Rezoning Transportation Analysis

Petition Number: 2020-026

Revision Log:

Date	Description
03-25-2020	First Review

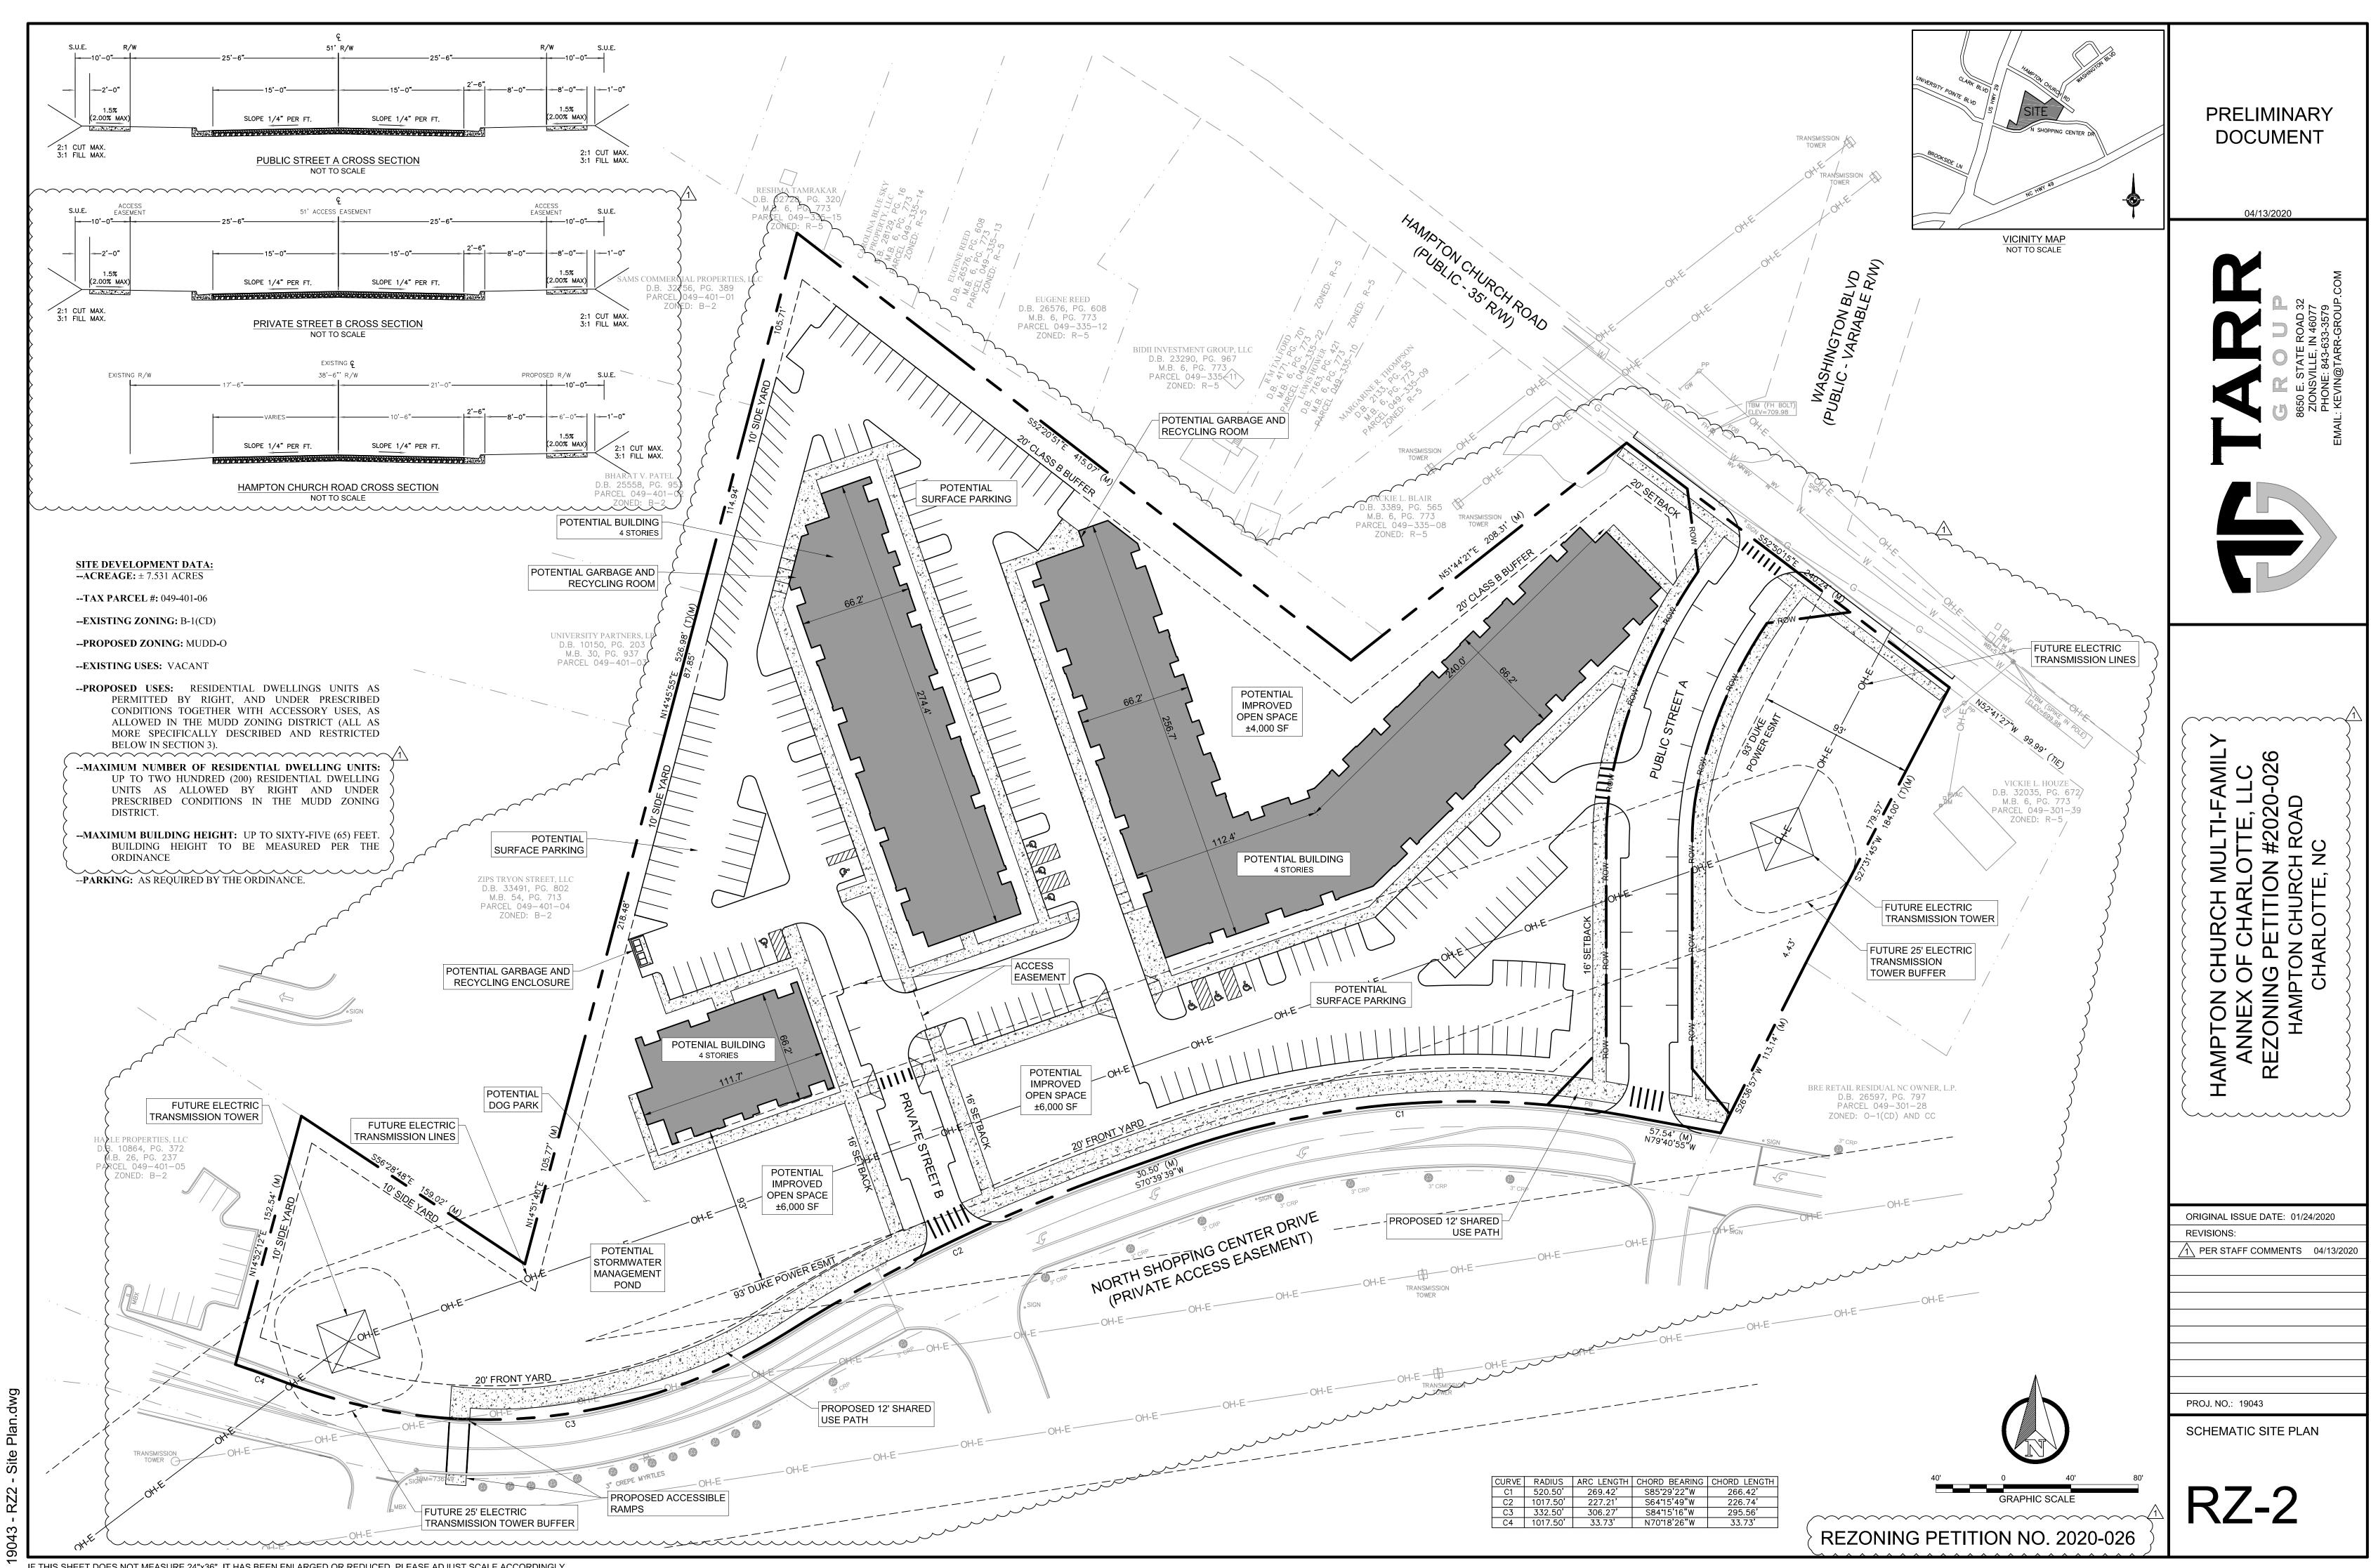
- ~~5. The petitioner should revise the site plan and conditional note(s) to align the proposed street and driveways across the street to provide a safer access. (Revised on 04-17-220)~~

6. The petitioner should revise the site plan to add a note specifying dedication and fee simple conveyance of all rights of way to the City before the site's first building certificate of occupancy is issued. CDOT requests right of way set at 2' behind back of sidewalk where feasible.
7. The petitioner should revise the site plan to add a note specifying all transportation improvements will be approved and constructed before the site's first building certificate of occupancy is issued. The petitioner may phase transportation improvements if said improvements and phasing are explicitly described in site plan notes.
8. **Resolved**-Sample format for comment that is resolved
